# Memo

**RE:** VA-15-00001 Heric

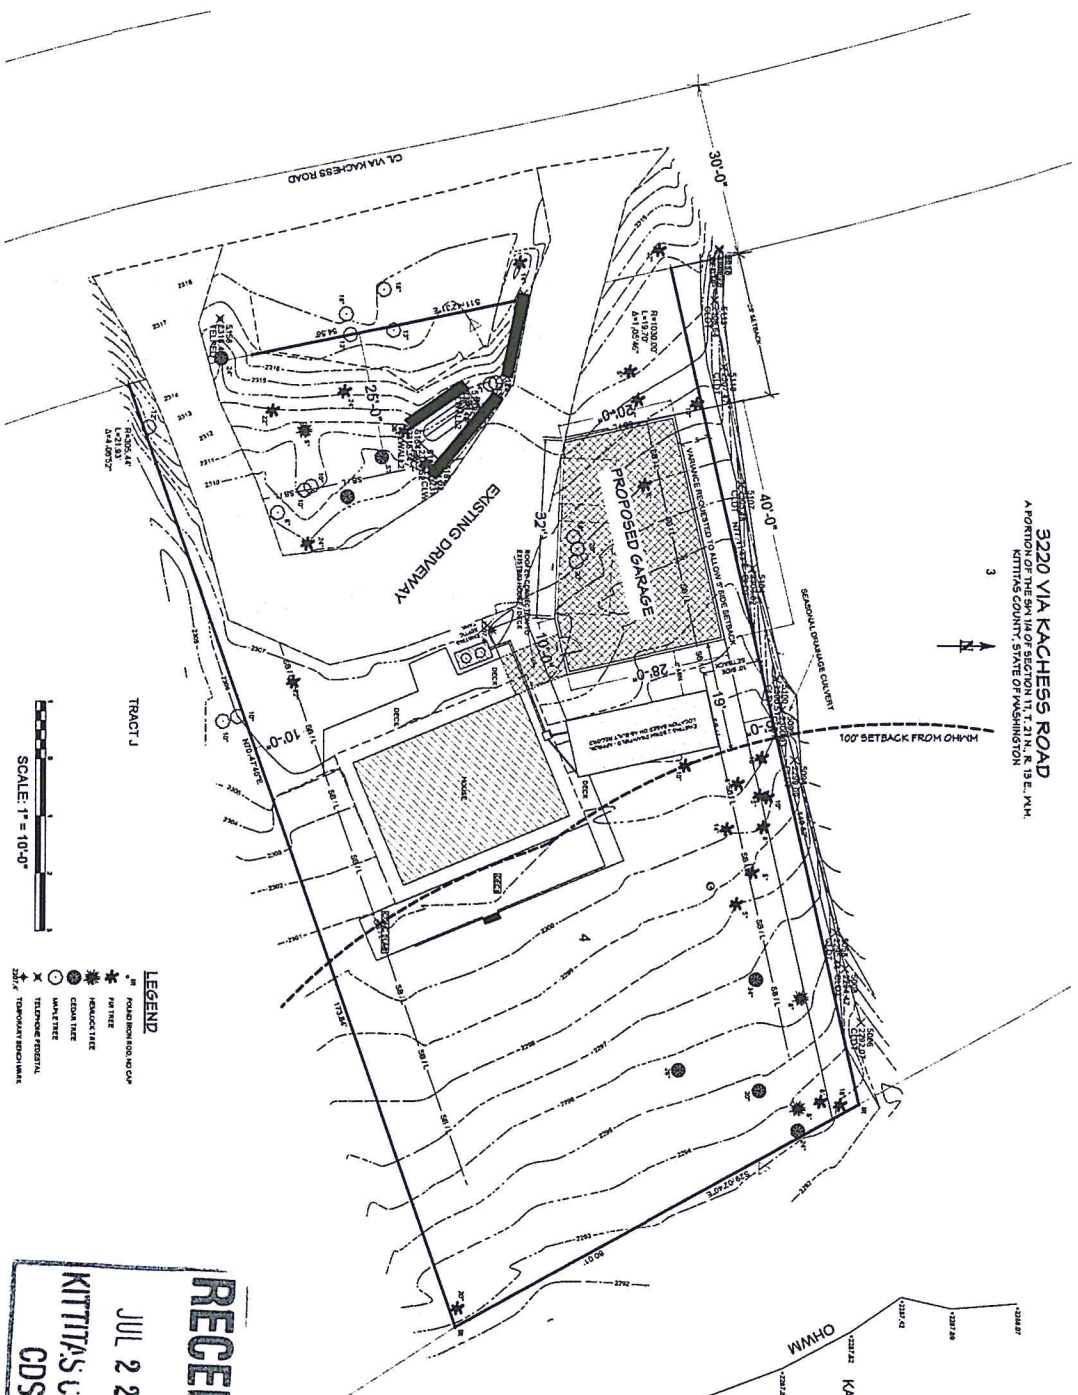
After review of this Zoning Variance land use application, it appears that the proposed structure will not impact the existing water source or septic system. The new garage structure must meet setback of 10 feet from septic drain field as per Kittitas County Code Chapter 13.04.080.
